# Rezoning Transportation Analysis

Petition Number: #2022-070

Date	Description
09-29-22	First Review (PDM)

**RZ-2.0**

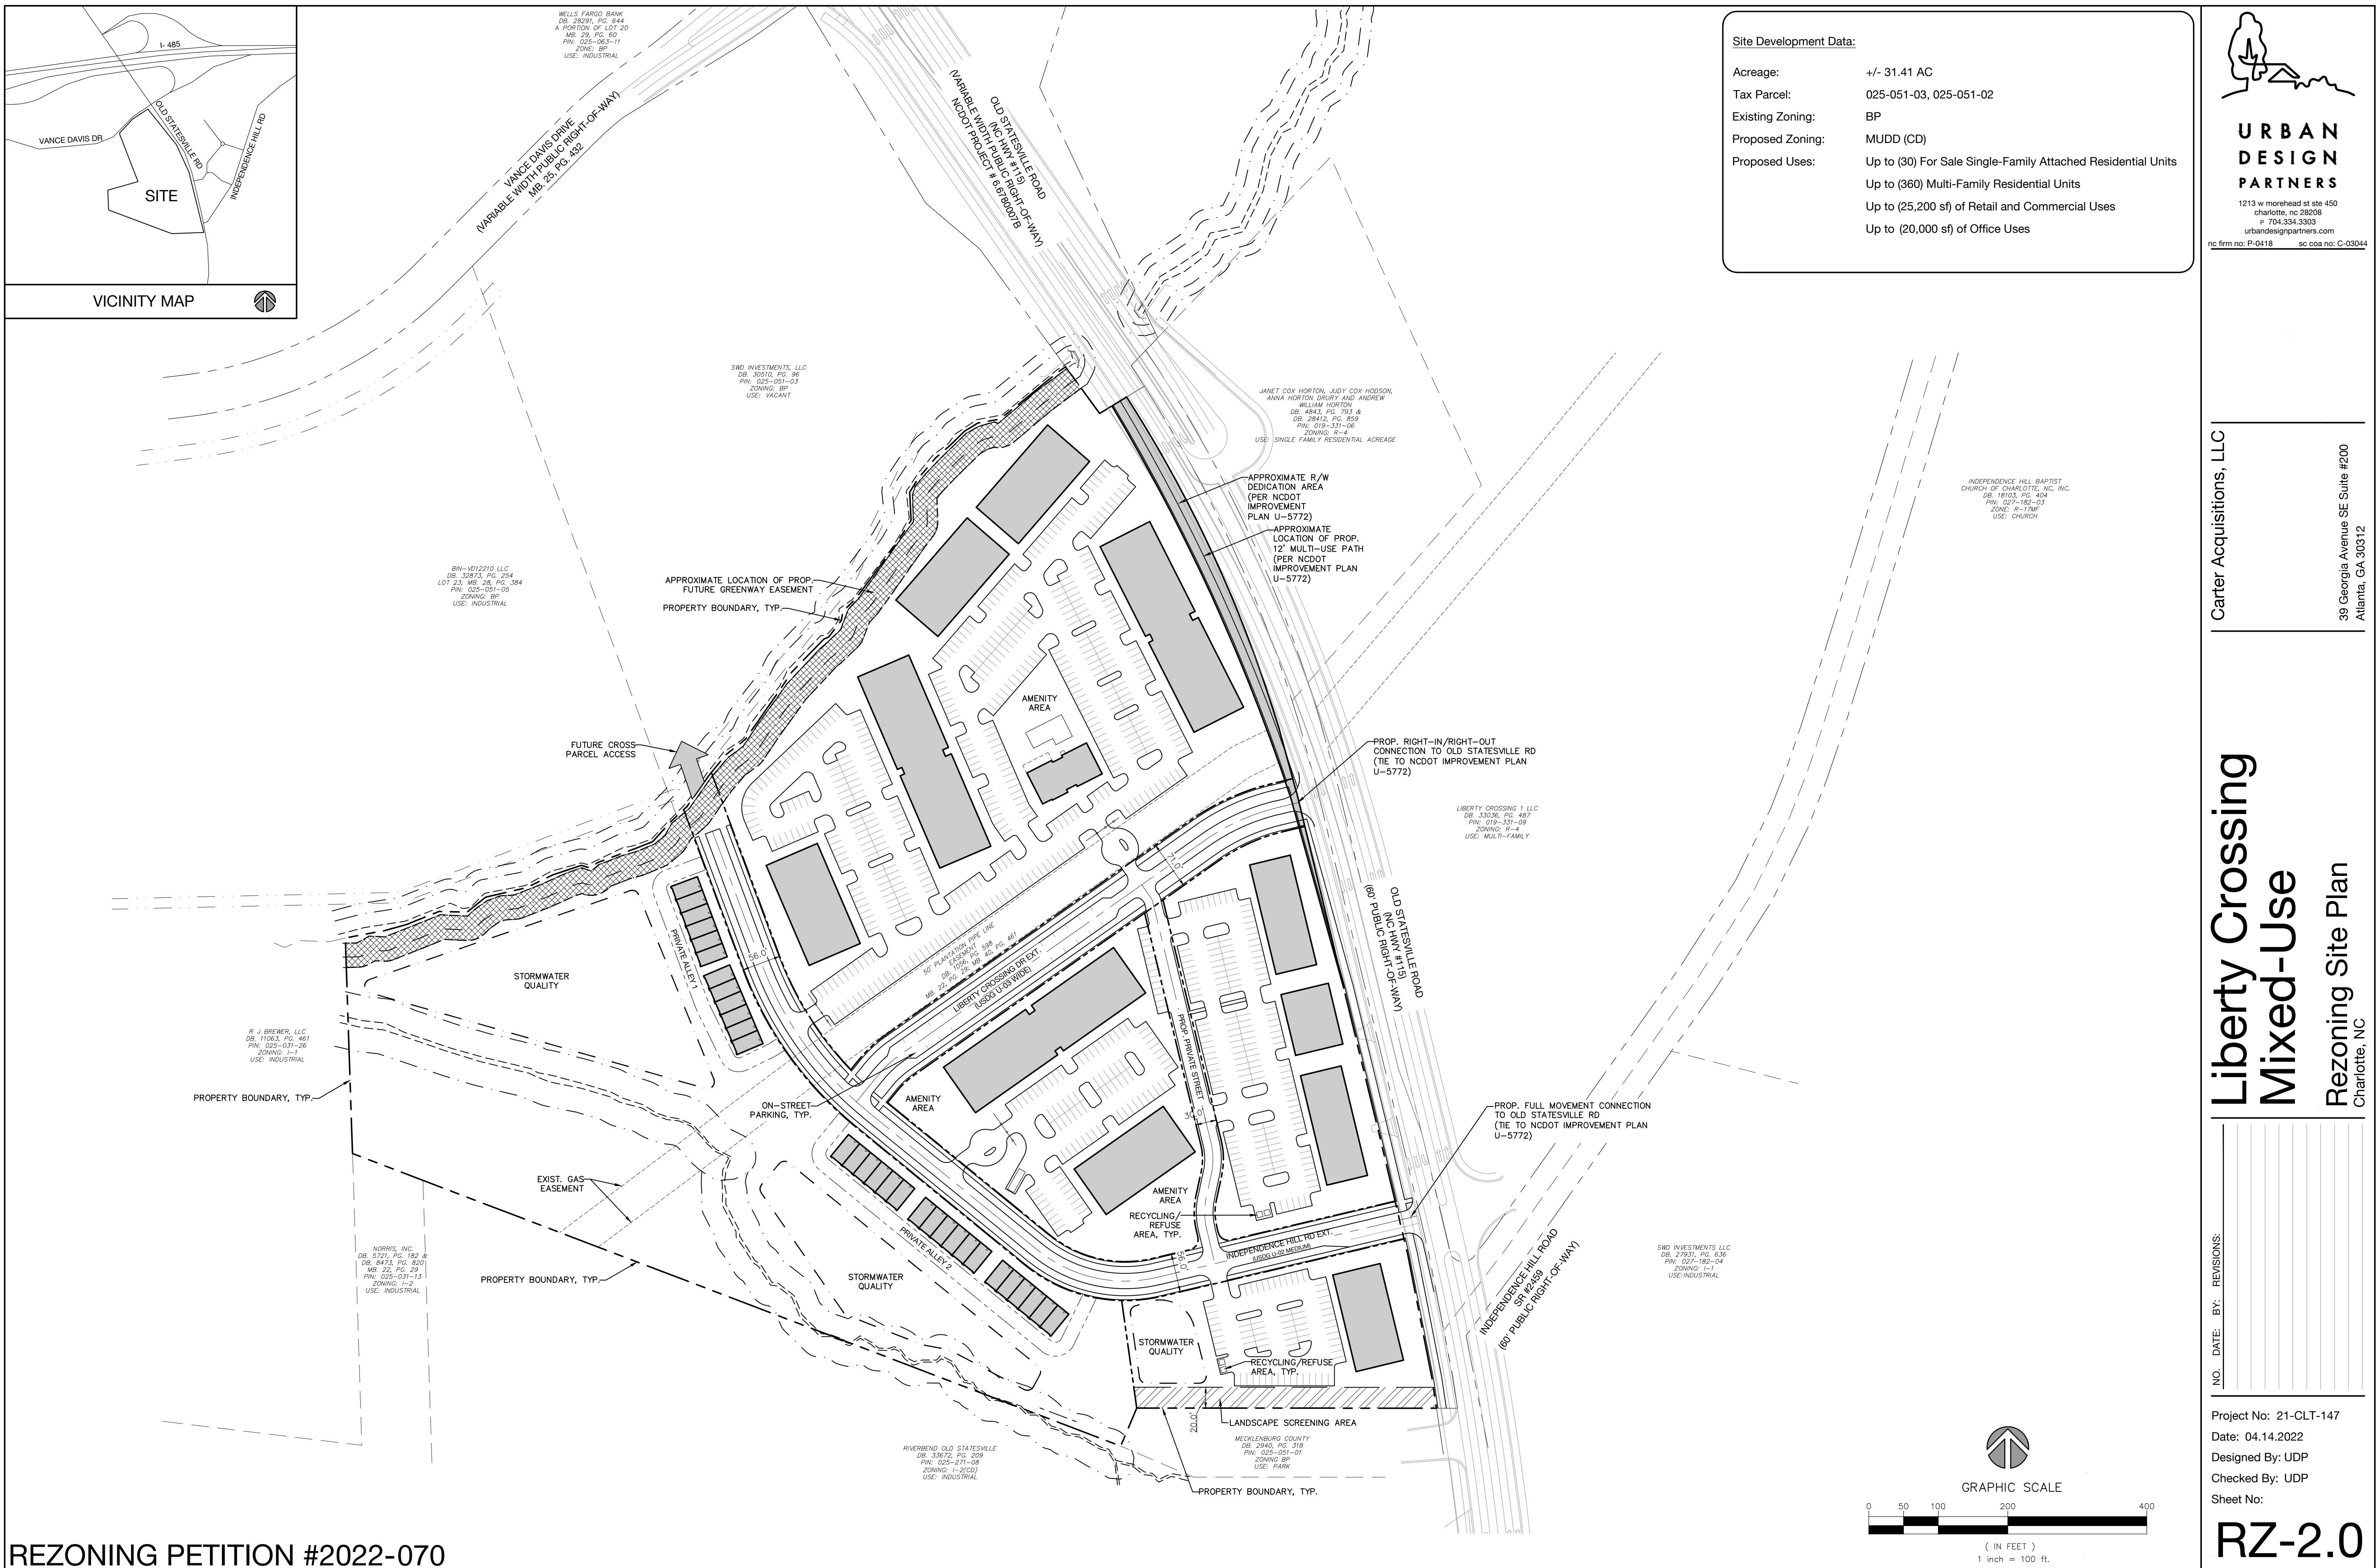
1. **Curbline:** The proposed zoning district has a setback measured from back of the existing or proposed future curbline.
  - a. **Old Statesville Road:** The future location of the back of curb and gutter shall be located at minimum 36-feet from the centerline of the roadway.

Label and dimension the curb and gutter from the centerline for each road on the site plan.

3. Revise site plan to dimension the proposed right-of-way along Old Statesville Road to be dedicated. The ROW dedication shall include the necessary widths to accommodate the NCDOT U-5772 project.

4. Revise site plan and conditional note(s) to identify Independence Hill extension and Liberty Crossing Drive extension roadways as public or private.

5. Revise site plan to dimension the 8-foot planting strip, and 8-foot sidewalk along the internal public roads per Chapter 19.
6. Confirm if the property will be annexed into the City of Charlotte. If the property will not be annexed into the City of Charlotte, the multi-use path along Old Statesville Road shall be located outside of the right-of-way with a public access easement.

7. Site plan and conditional note(s) revisions are needed to commit to constructing a temporary turn around at the proposed future cross parcel access on Independence Hill Road extension in accordance of CLDSM 11.18B.
